Green Hill Solar Farm

EN010170

Statement of Common Ground: Milton Keynes City Council Revision A

Document Reference: EX4/GH8.3.3_A
Infrastructure Planning (Examination Procedure) Rules 2010

Figure 4.20
Green Hill Site G
Landscape and Ecology Mitigation Plan
[EN010170/APPGH6.4.4.20]
5/2(a)

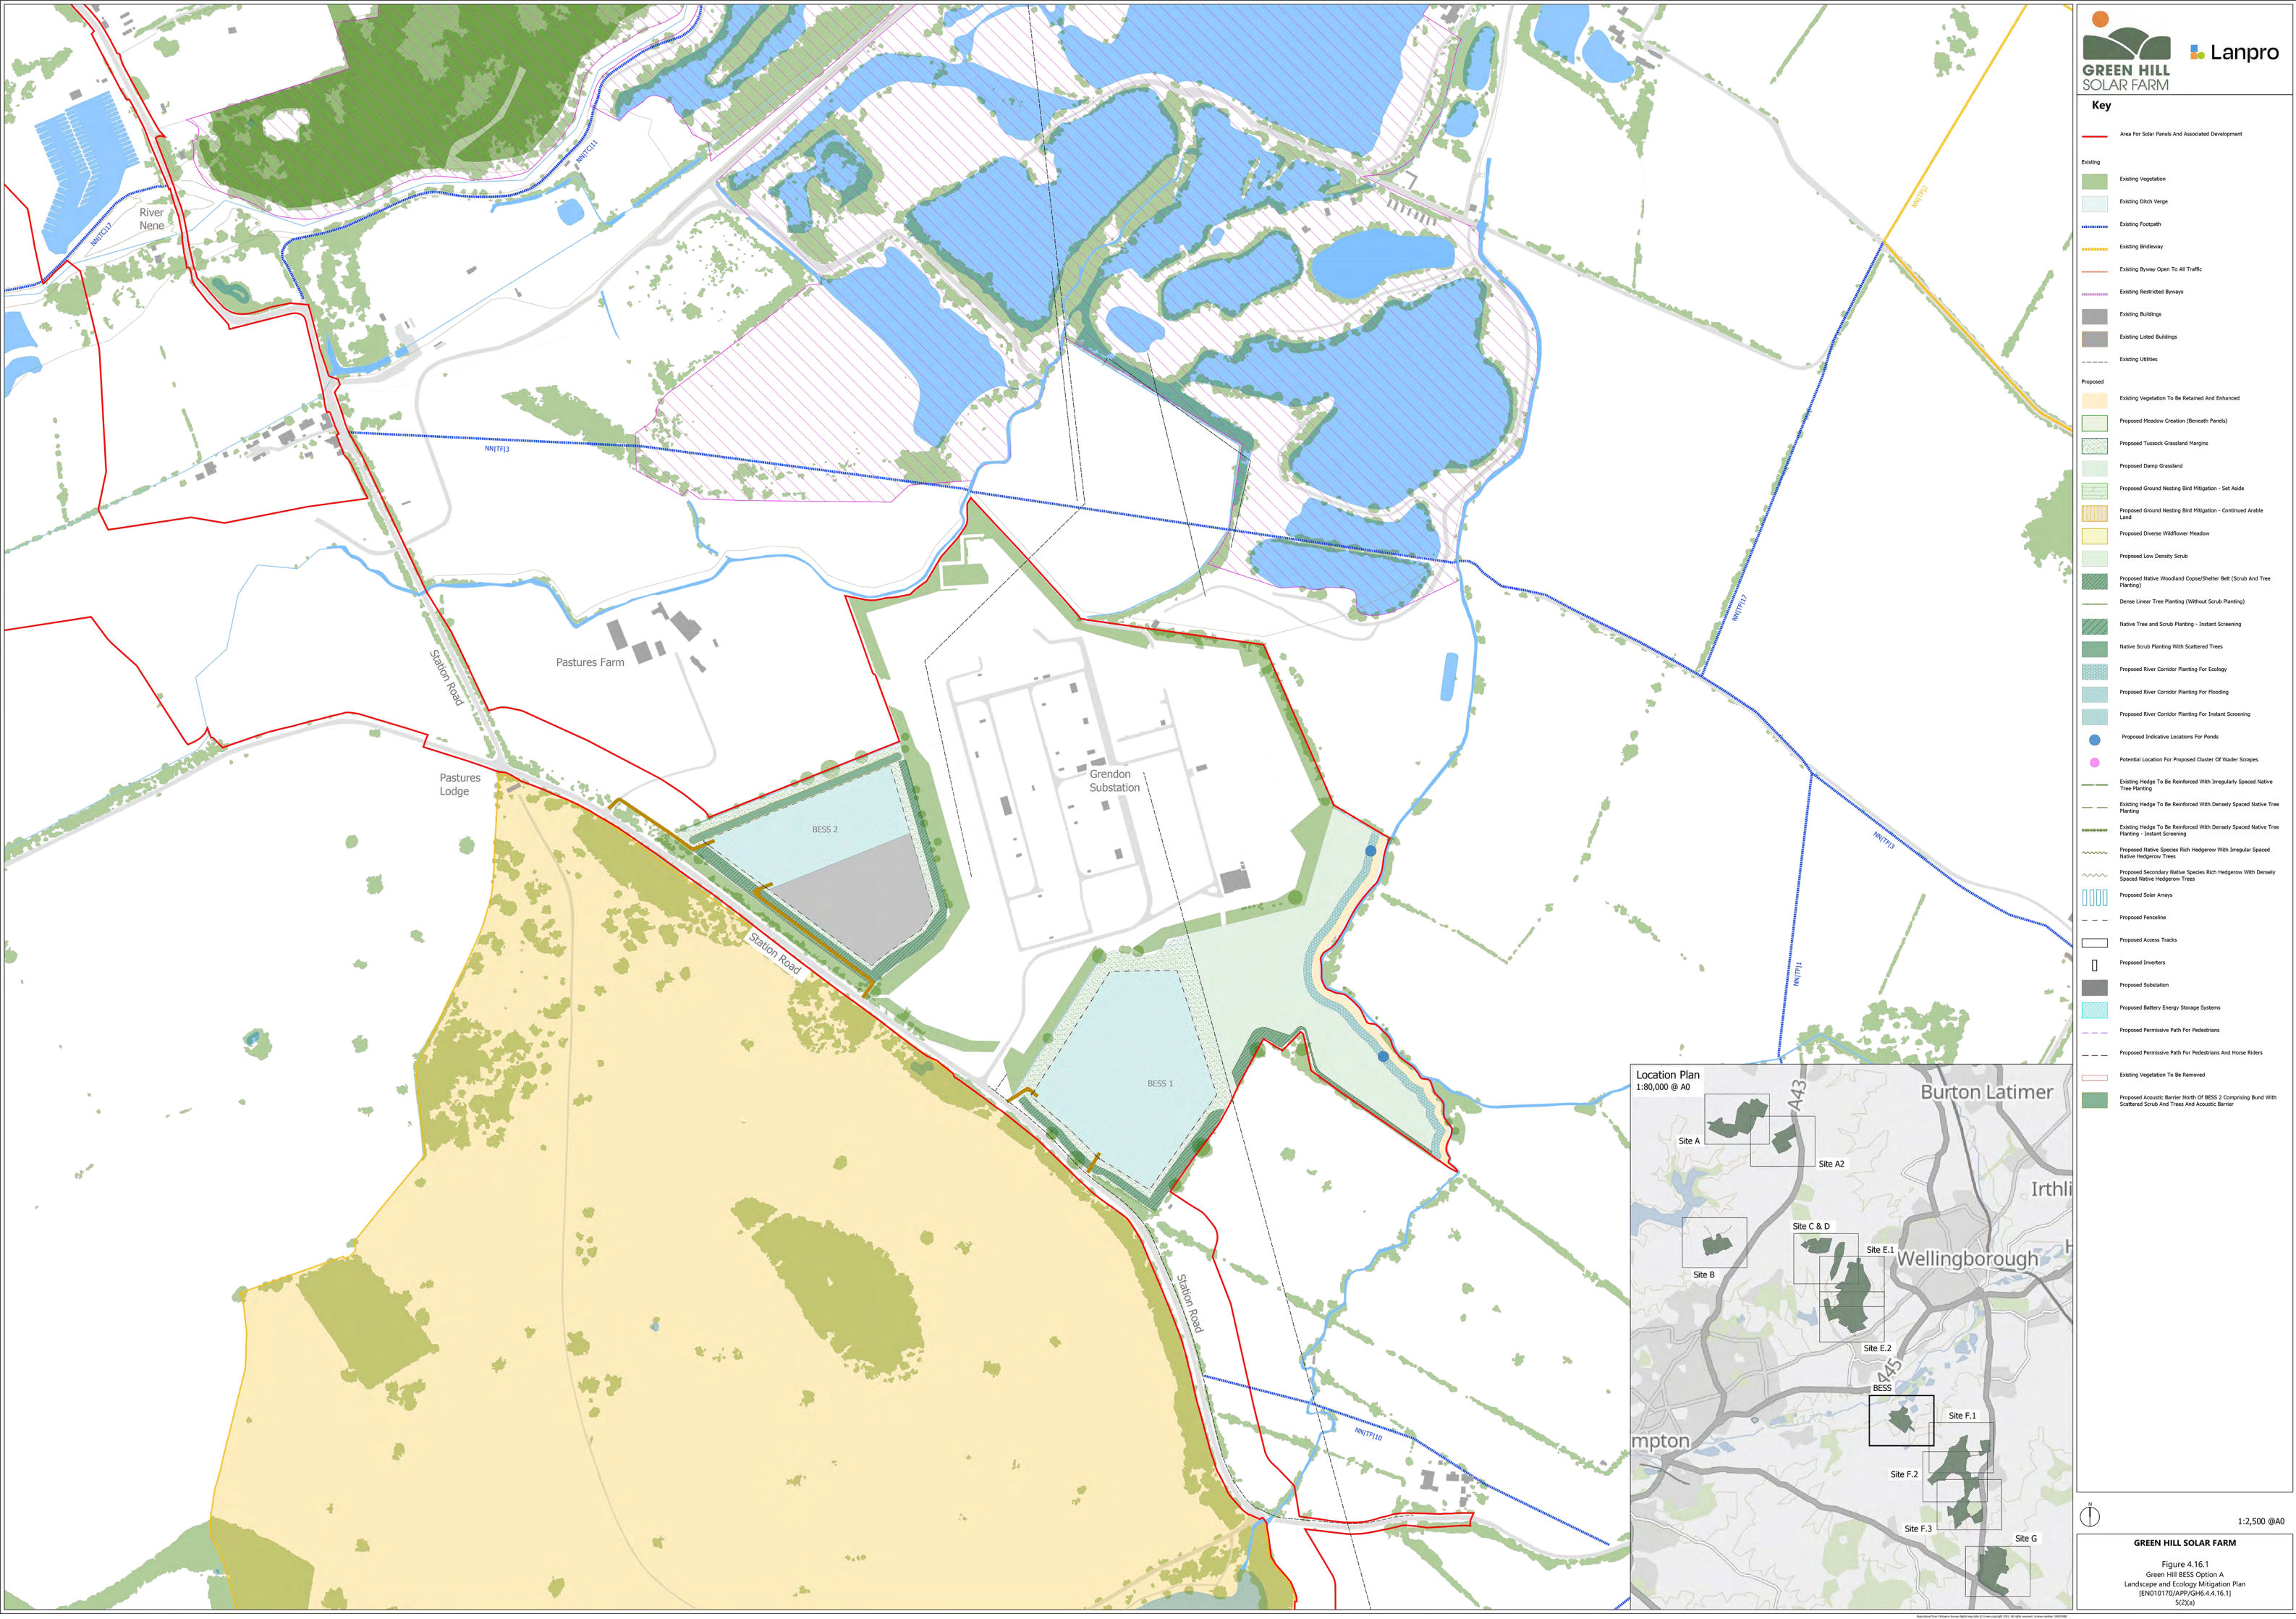
Matter	Details of Matters for Discussion	Applicant Position	Consultee Position	Status
			provide context and identify what the key issues are.		
LVIA-12	Landscape and Ecological Management Plan: Landscape and Ecological Improvements	Landscape and Ecology Mitigation and Enhancement Plans (Figures 4.10-4.20) [REP3-042, REP3-044, APP-209, REP3-046, APP-211, REP3-048, REP3-050, APP-214, APP-215, REP3-052, APP-217, REP3-054, APP-219] Outline Landscape and Ecological Management Plan [REP3-062]	<p>The landscape and ecological improvements are set out in the Landscape and Ecology Mitigation and Enhancement Plans (Figures 4.10 to 4.20). The Outline Landscape and Ecological Management Plan [REP3-062]</p> <p>Following further development of the Scheme, more detailed planting plans including detail of areas of landscape mitigation, location and types of planting (species), as well as number, density and specification will be provided prior to any works commencing. The detailed landscape proposals will consist of the area and extent of the Scheme shown on Landscape and Ecology Mitigation and Enhancement Plans (Figures 4.10-4.20). The Outline Landscape and Ecological Management</p>	Requests made for further enhancements (as per LIR)	Matter Under Discussion
